Report of the Head of Development Management and Building Control

Address: 11 ROY ROAD NORTHWOOD

Development: Demolition of existing garage and erection of an outbuilding to the rear garden (Application for a Certificate of Lawful Development for a Proposed Development).

LBH Ref Nos: 9510/APP/2025/1326

Project:	11 Roy Road
Client:	Param Patel
Drawing:	Location and Site Plan
Date:	23/04/24
Scale:	As indicated @ A1
Drawn By:	AT
Drawing No:	1586_0001
Revision	1
Preliminary [X]	Tender [] Construction []

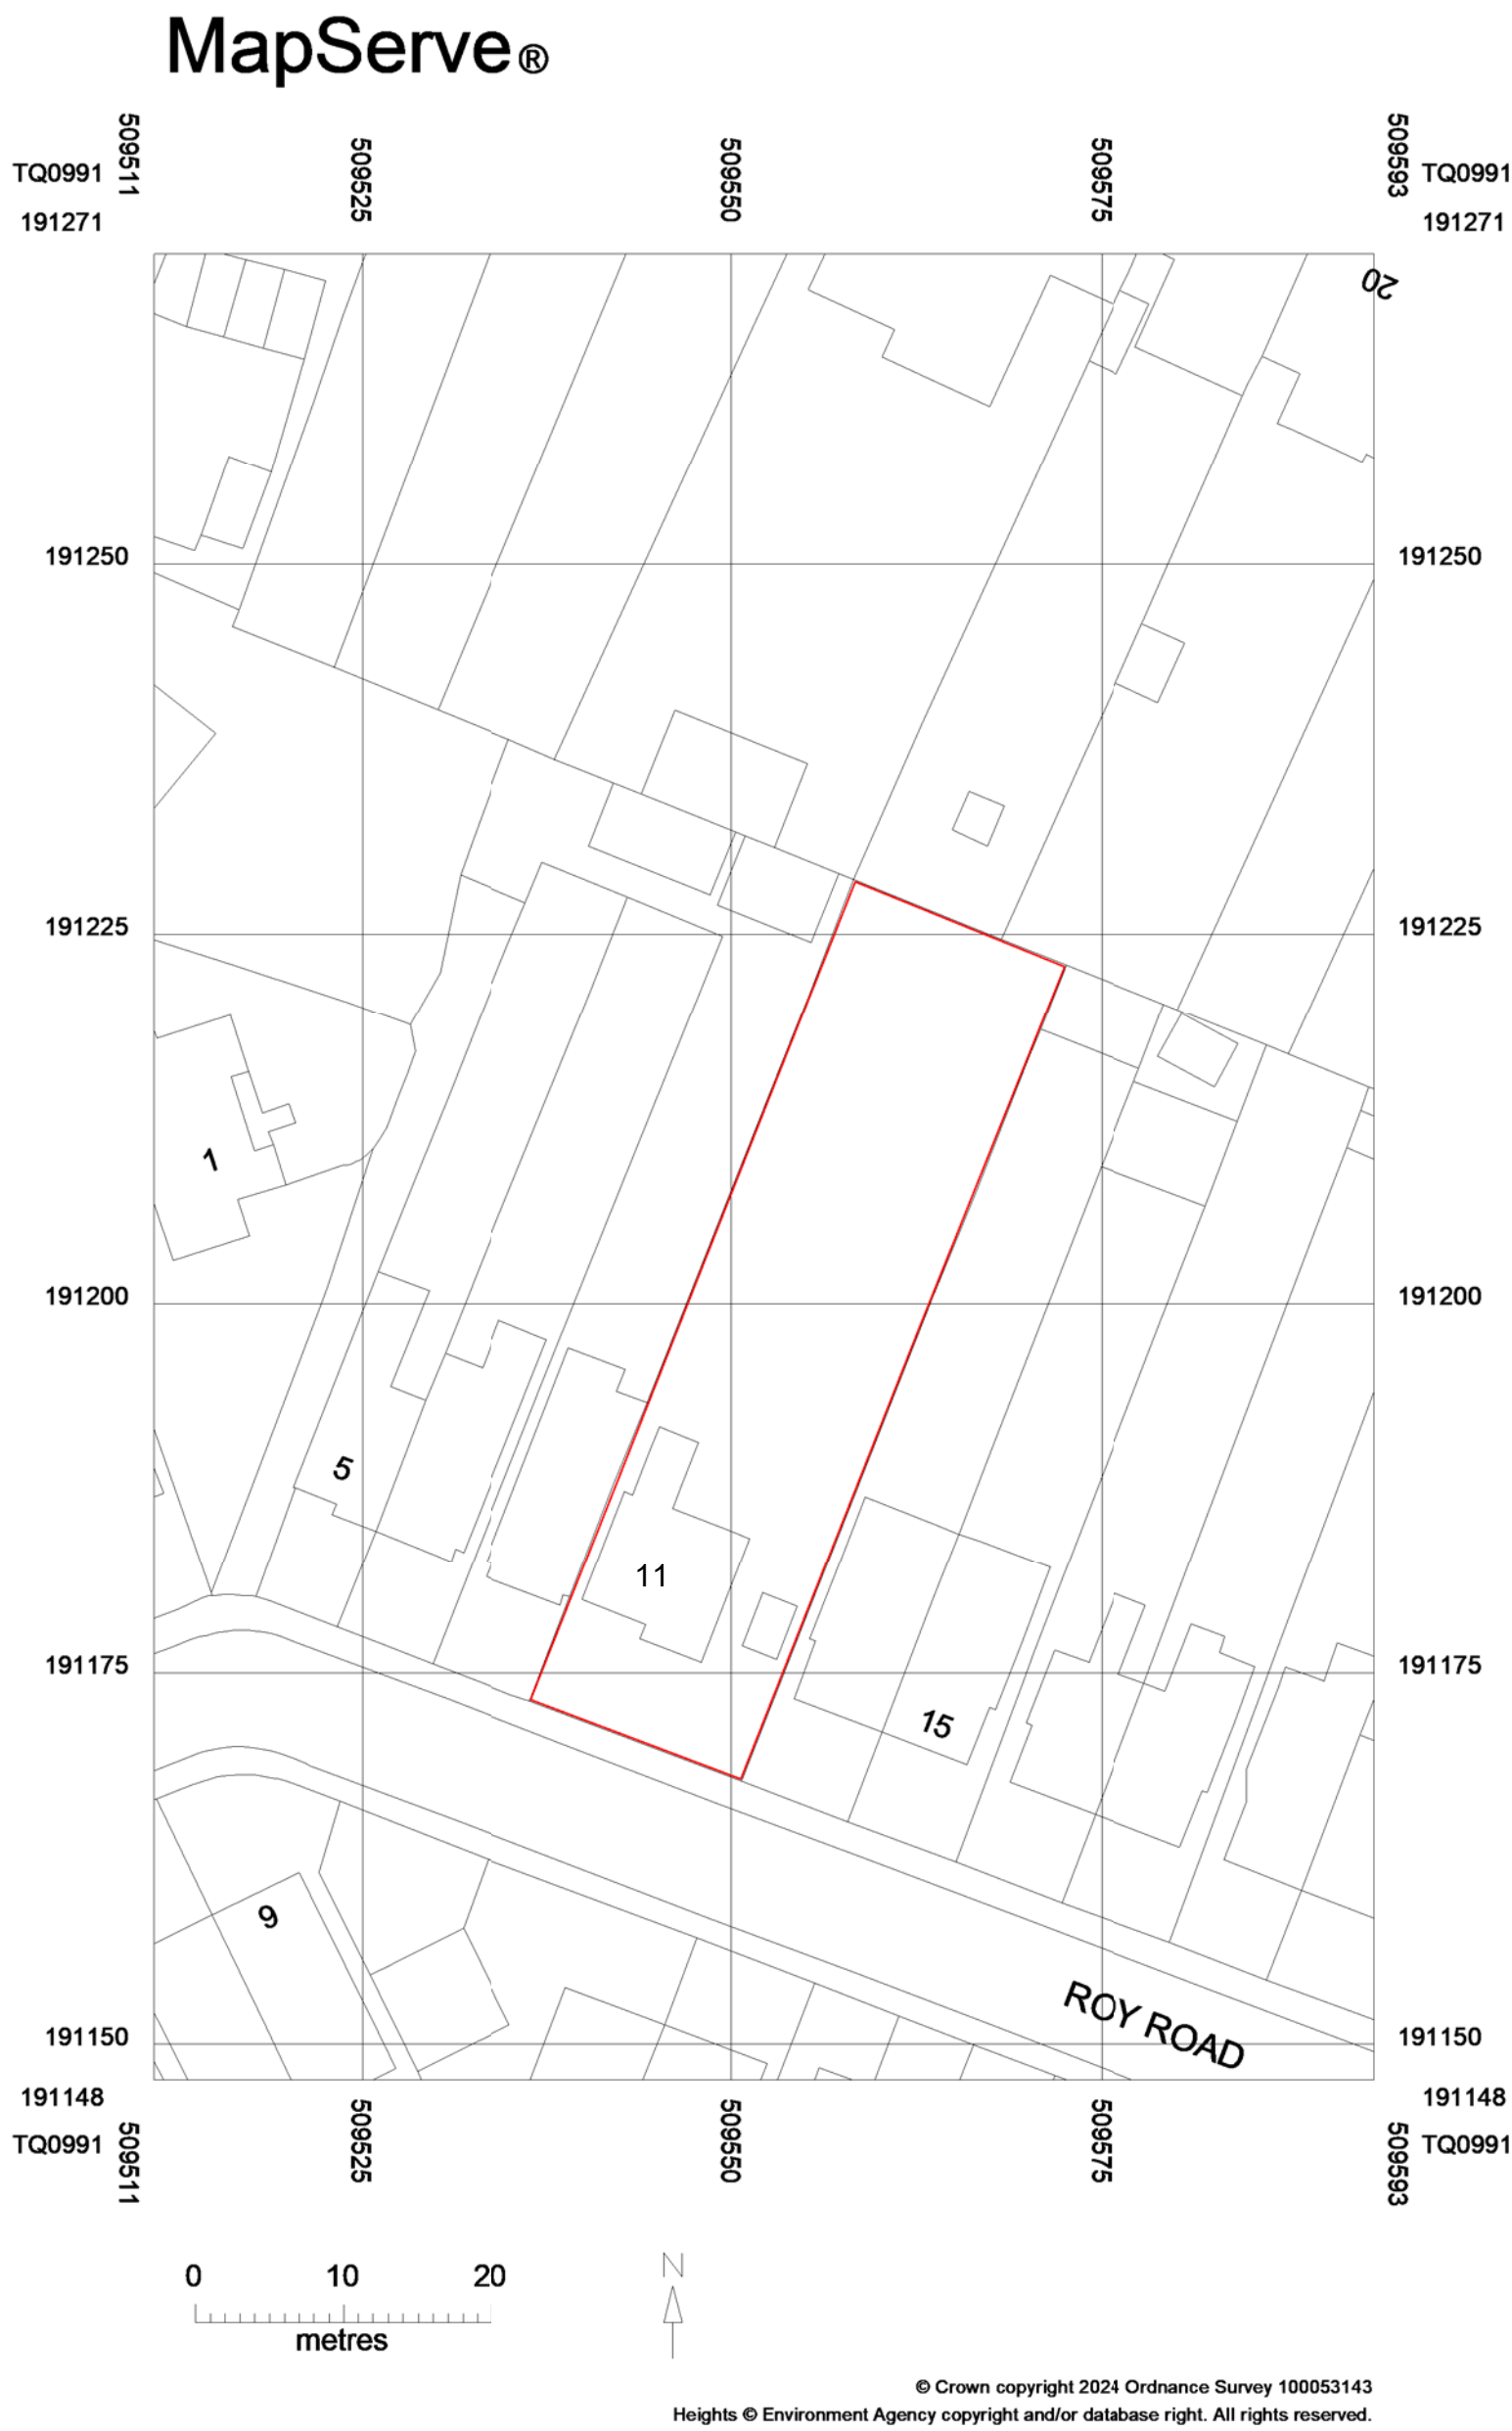
In this case, the proposed outbuilding would have a footprint of 128.23sq.m. The proposed outbuilding would provide a garage, two offices, a store room, plant room, toilet and gym. No kitchen facilities would be provided.

The existing garage located at the side of the application property would be removed. The existing site access would be retained, and the existing driveway would be extended to the rear garden in order to provide access to the garage within the proposed outbuilding. Given the overall size/footprint of the proposed outbuilding and that the proposal would create a vehicular access to the rear of the application site, it is considered that the proposed outbuilding could be used as a self-contained unit.

Whilst the provision of a garage, two offices, a store room, plant room, toilet and gym, could individually be considered to be incidental uses, given the overall size and scale of the proposed outbuilding, the potential for the outbuilding to be used as a self-contained unit, that the footprint of the proposed outbuilding would be 32% larger than the footprint of the existing dwellinghouse, and that no information has been provided by the applicant to explain why an outbuilding which equates to 128.23sq.m is reasonably required, it is considered that it has not been demonstrated that the proposed outbuilding would be reasonably required for a purpose incidental to the enjoyment of the dwellinghouse at 11 Roy Road.
